DEVELOPMENT REVIEW BOARD  
TRANSPORTATION DEVELOPMENT

DRB Project Number: 2019-002046  
Edith Solid Waste Facility

SUBJECT: Site Plan

DATE: December 18, 2019

LANDSCAPE PLAN

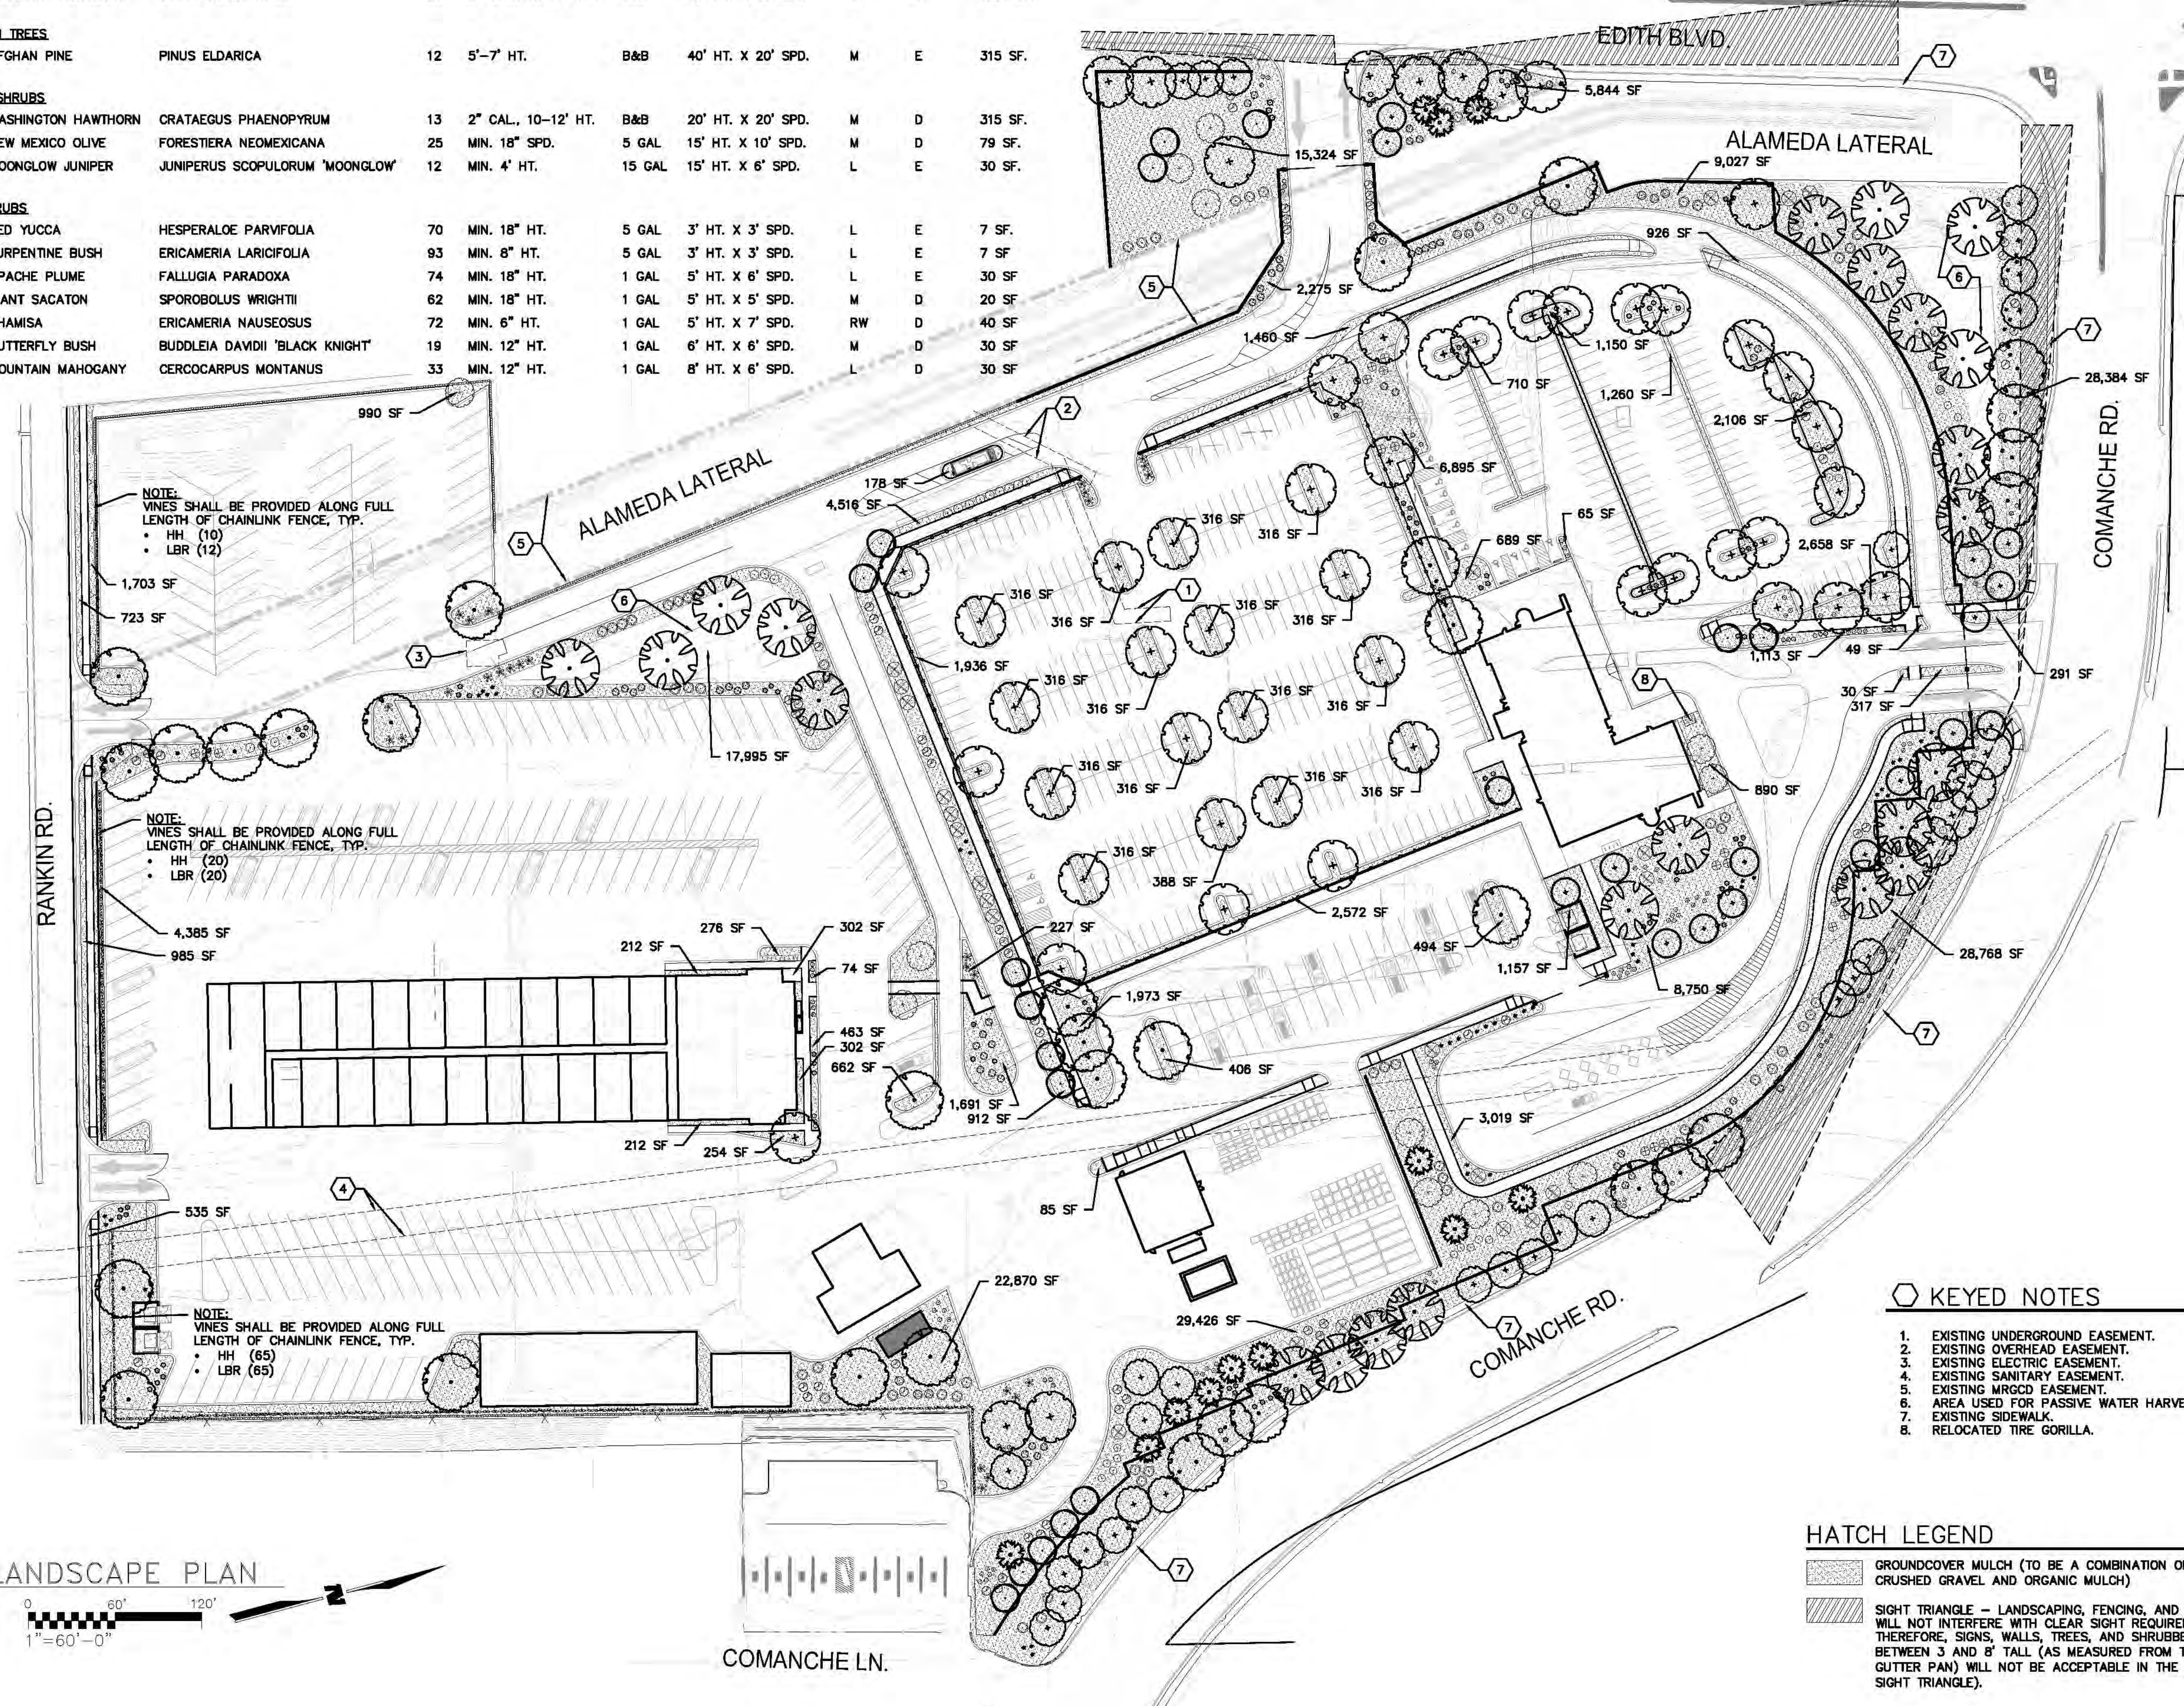
5. Provide details of the sign (keyed note #10). Also, provide a clear sight triangle at this access point to show that the sign is outside the triangle. Show clear sight triangles on other access points as well. (Clear sight triangles also need to be provided on the landscaping plan to make sure that there are no sight distance issues. Add the following note as well: “Landscaping, fencing and signing will not interfere with clear sight requirements. Therefore, signs, walls, trees, and shrubbery between 3 and 8 feet tall (as measured from the gutter pan) will not be acceptable in the clear sight triangle.”)

ROADWAY TYPICAL SECTION - RANKIN RD.

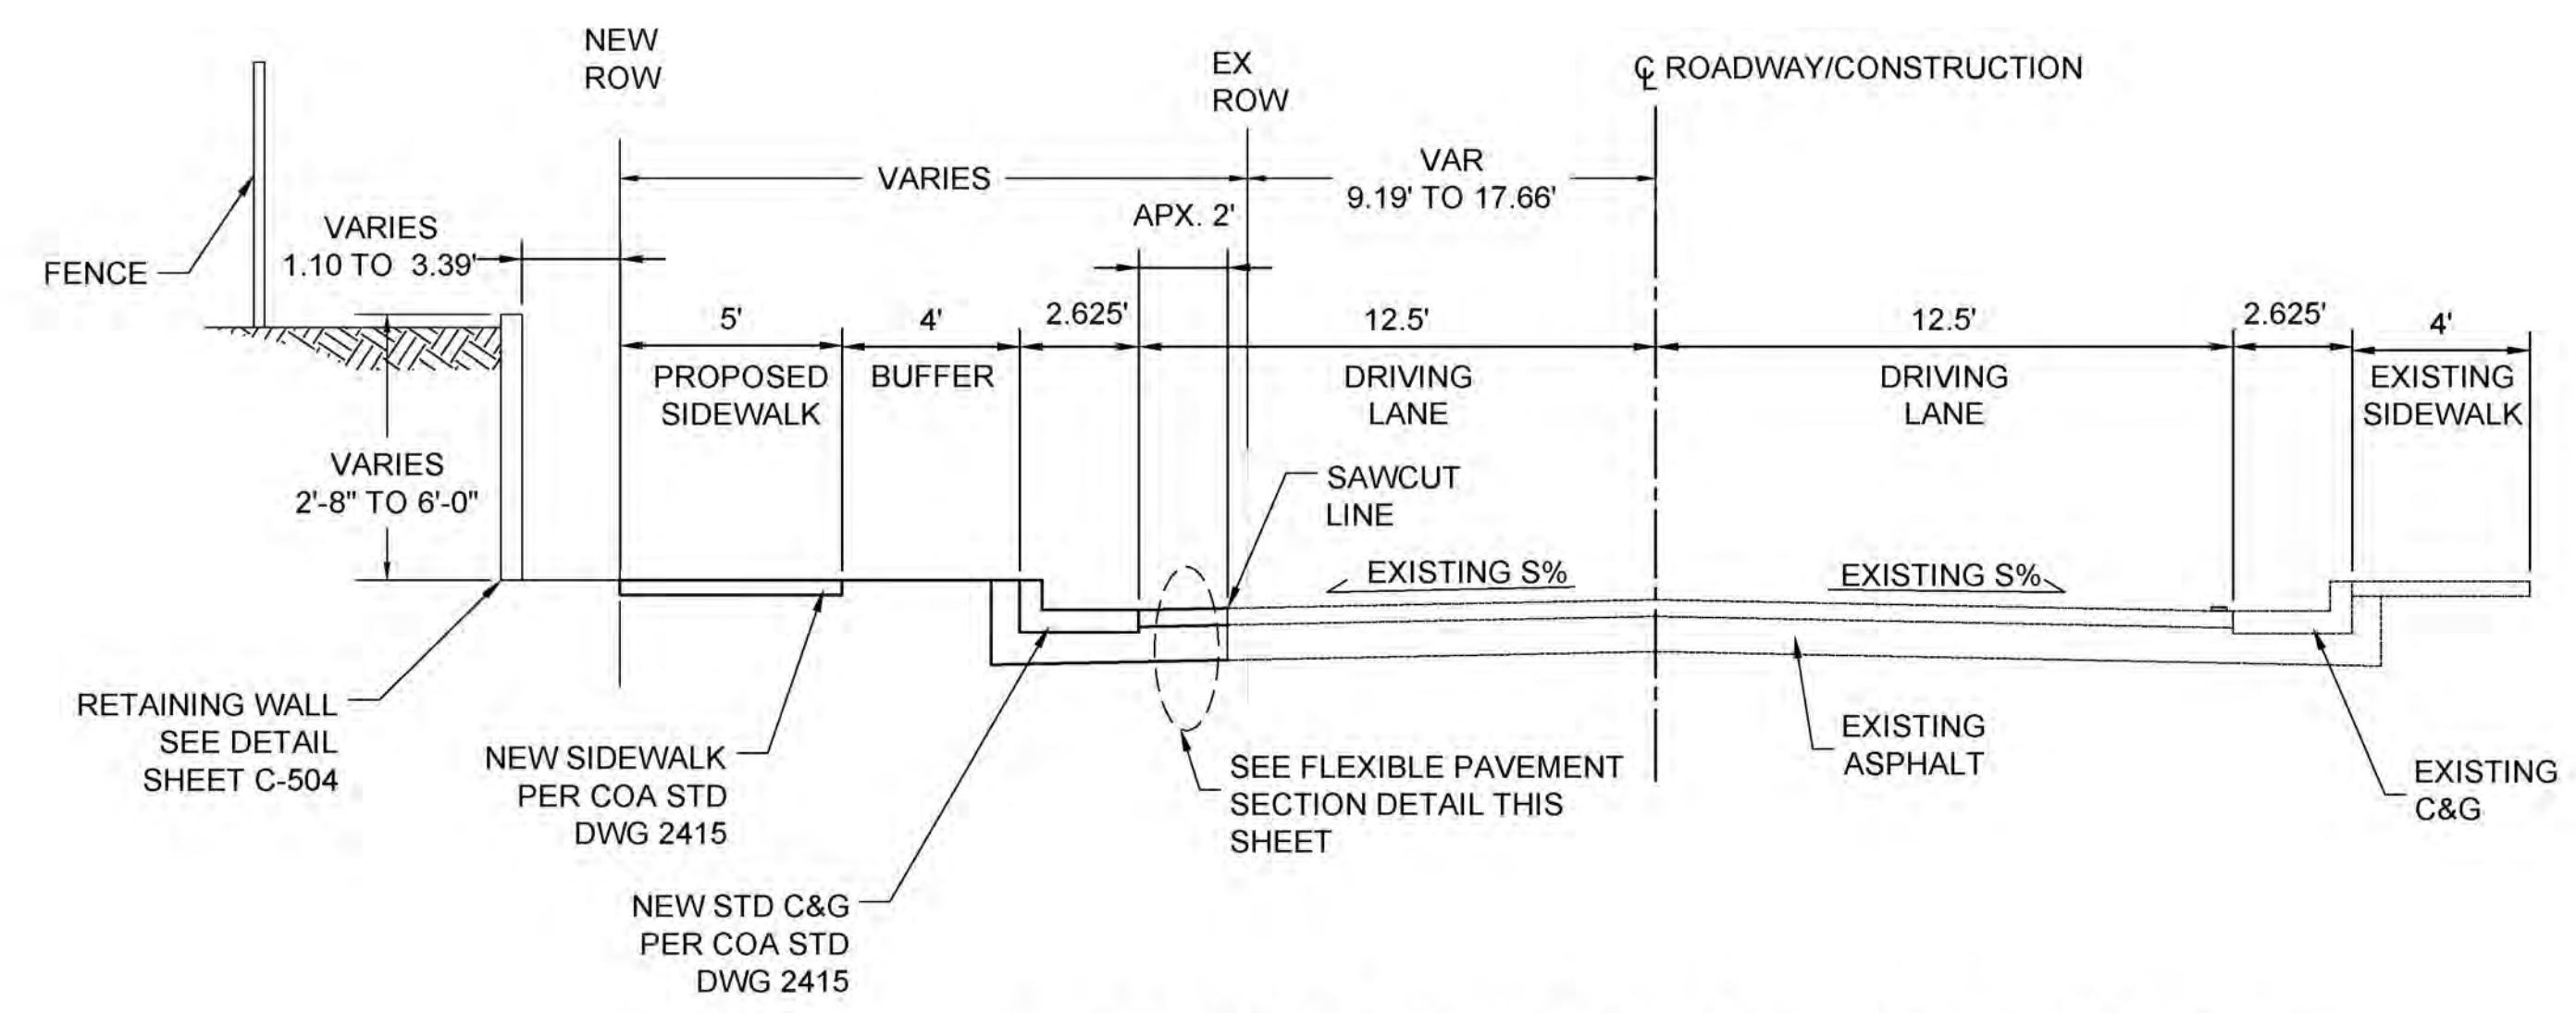
1. Add the DRB signature block for approval.
2. On the south side of the property along Rankin Road, right-of-way dedication is required as well as infrastructure for the curb and sidewalk shown on the plan. (Also provide a road cross-section for Rankin.)

SITE PLAN DRB

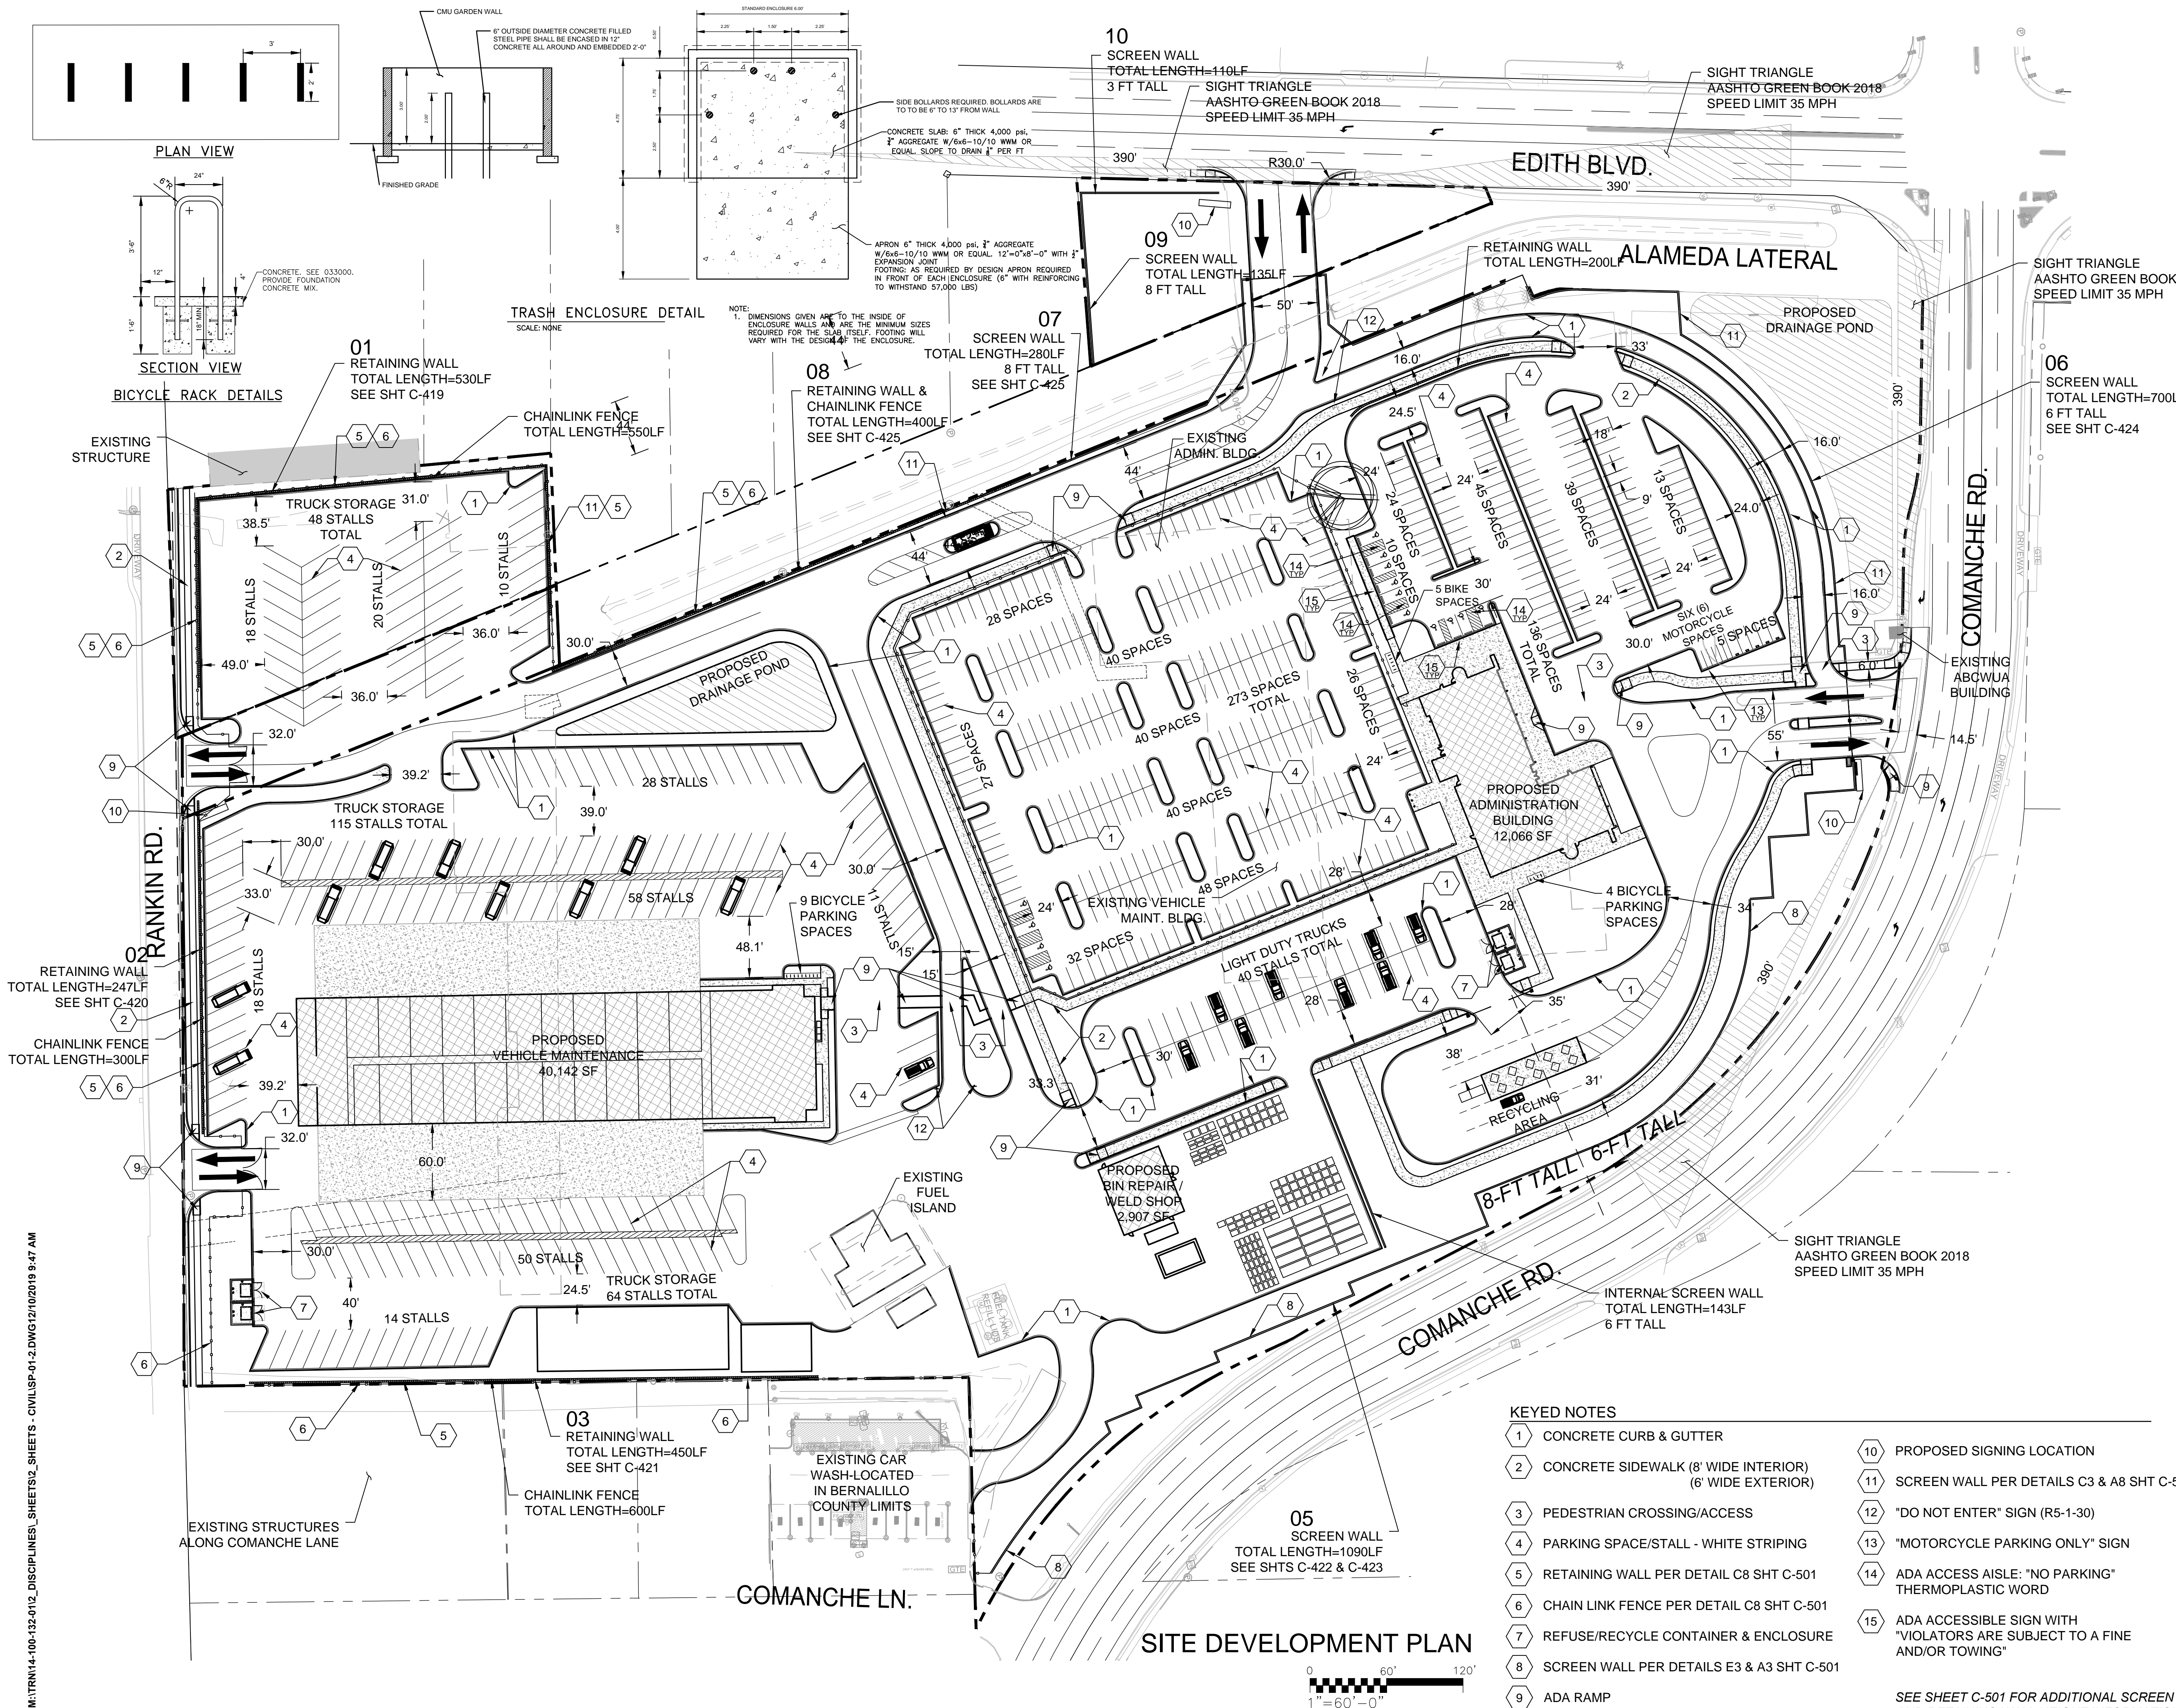
3. Show all drive aisle widths, and provide all site dimensioning including curb radii information, parking space dimensions, etc.
4. One-way vehicular paths require pavement directional signage and a posted **“Do Not Enter”** sign at the point of egress. Please show detail and location of posted signs.

6. Has a turning template design been provided to demonstrate that aisle widths will work for the Solid Waste Vehicles?
